Your Ref: OWPC16781
Our Ref: FG/115/17/PL 17-07-2017
Please ask for:
Mrs A Gardner

4 No. bungalows
44 Ferringham Lane Ferring

Thank you for your internet representation made on 1st January 2018 which has been recorded as '**an objection**' with the comments as follows:

Site layout block plan

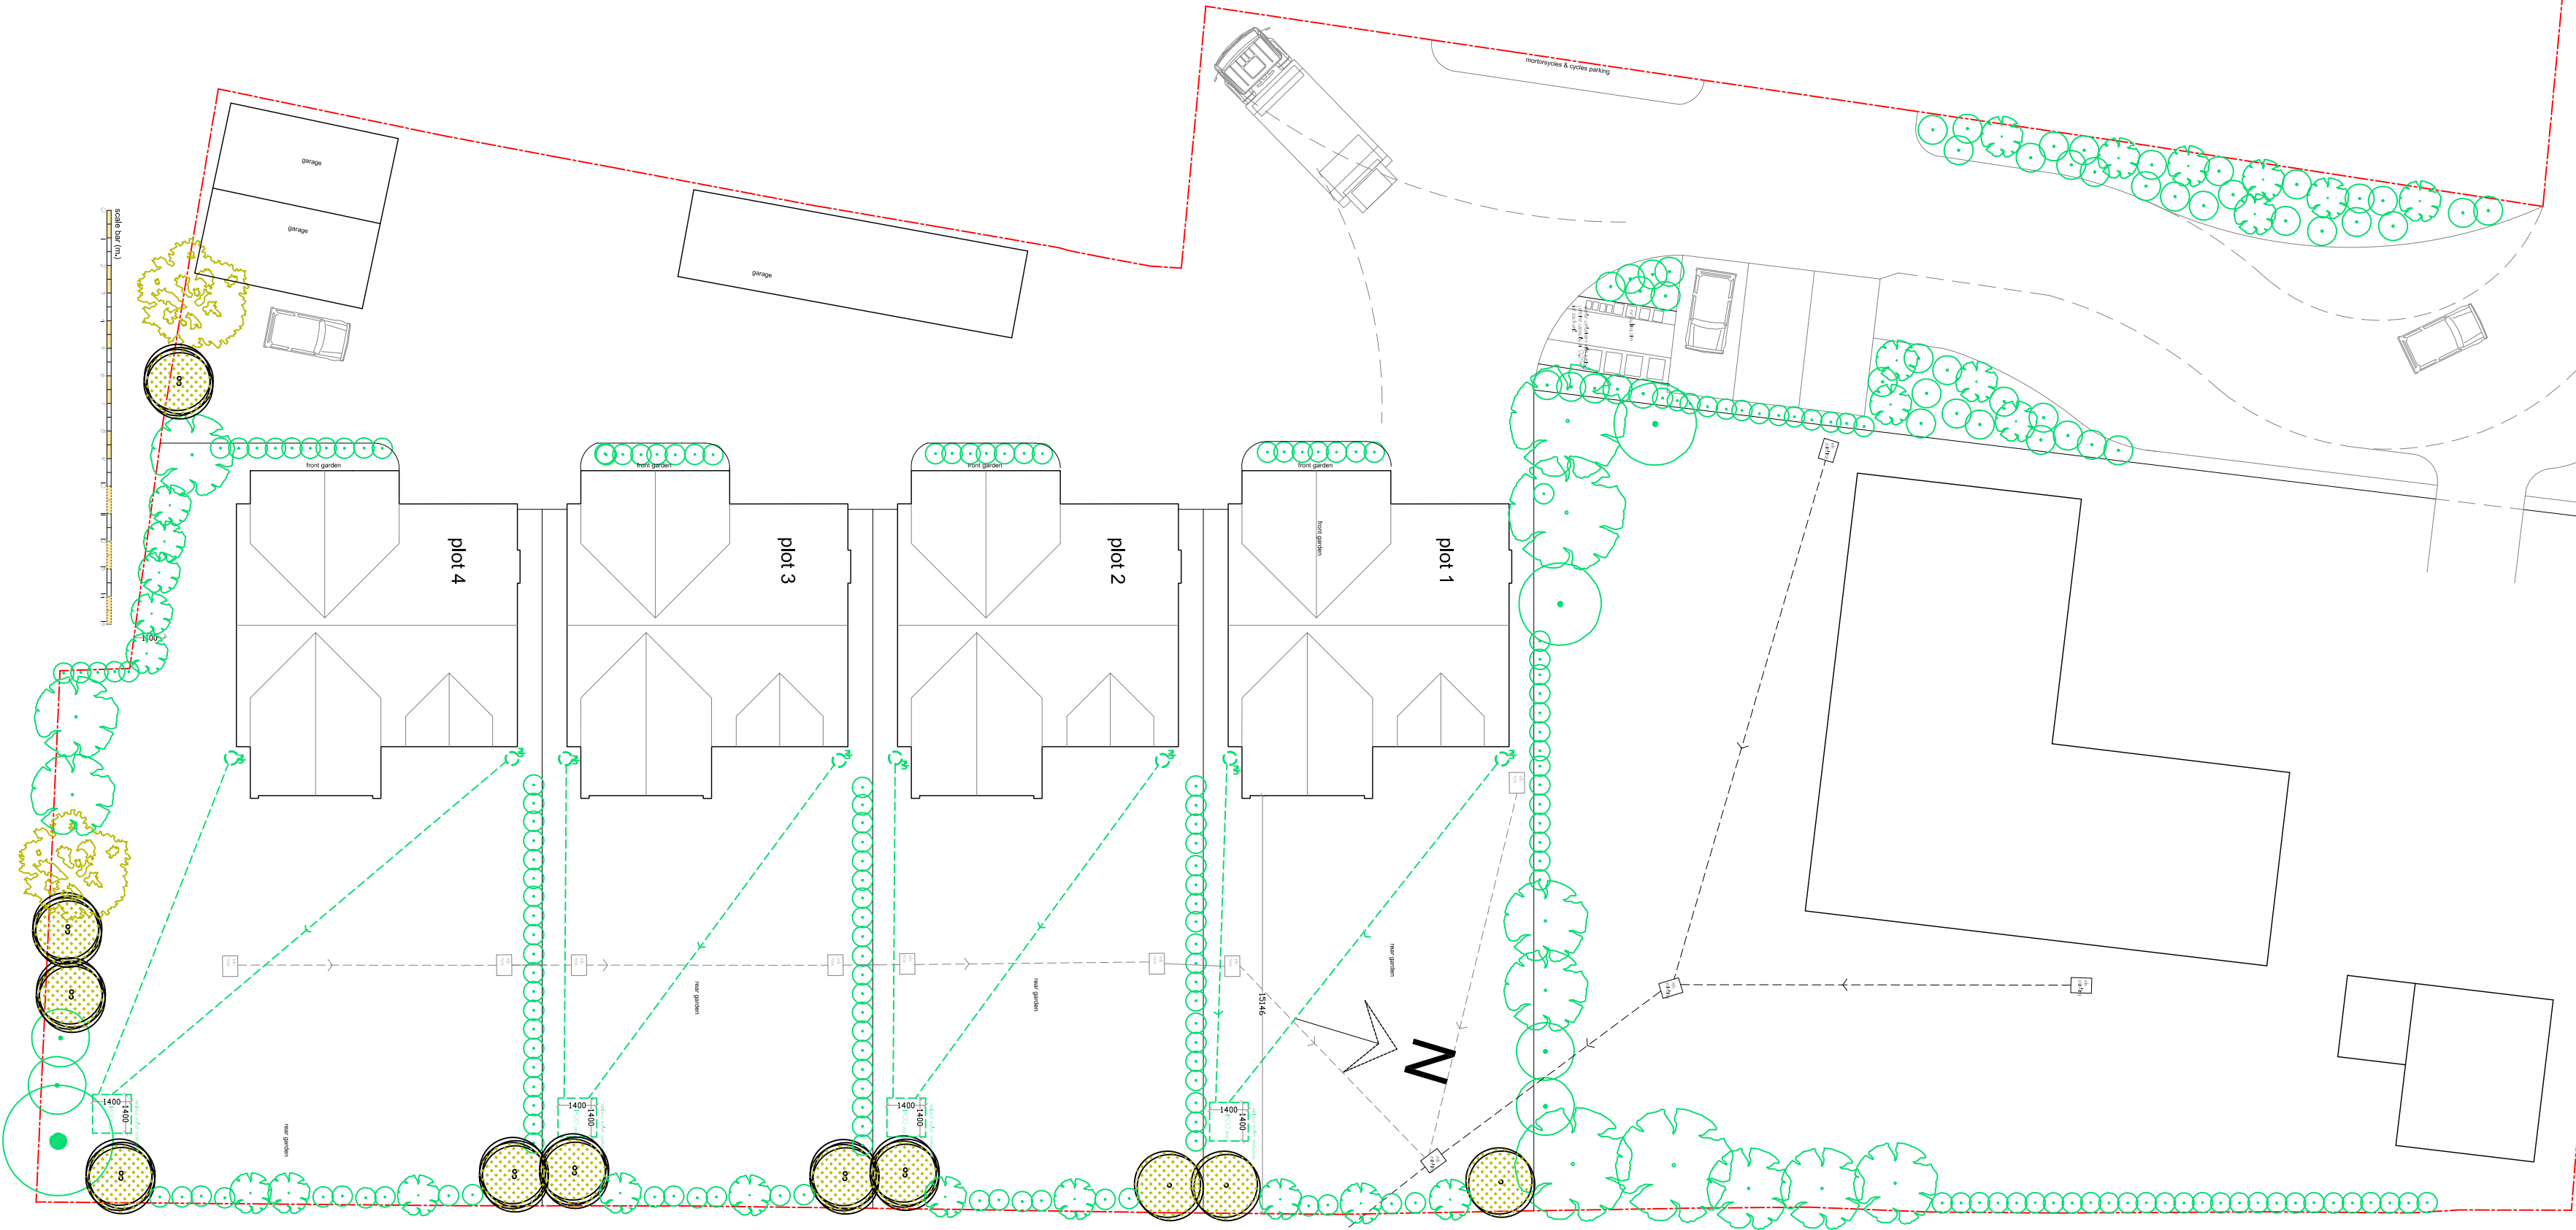
This latest extension of application time, due to planning ammendments compliance, has still done nothing to address the conditions imposed by the Planning Inspectorate as detailed in my earlier objection to this application. These latest alterations are therefore immaterial.

The conditions regarding access width, visibility splay and traffic v pedestrian safety are key to the approval of this application. They have not been met in this submission. Fellow objectors, together with our local parish council, have repeatedly pointed out this detail.
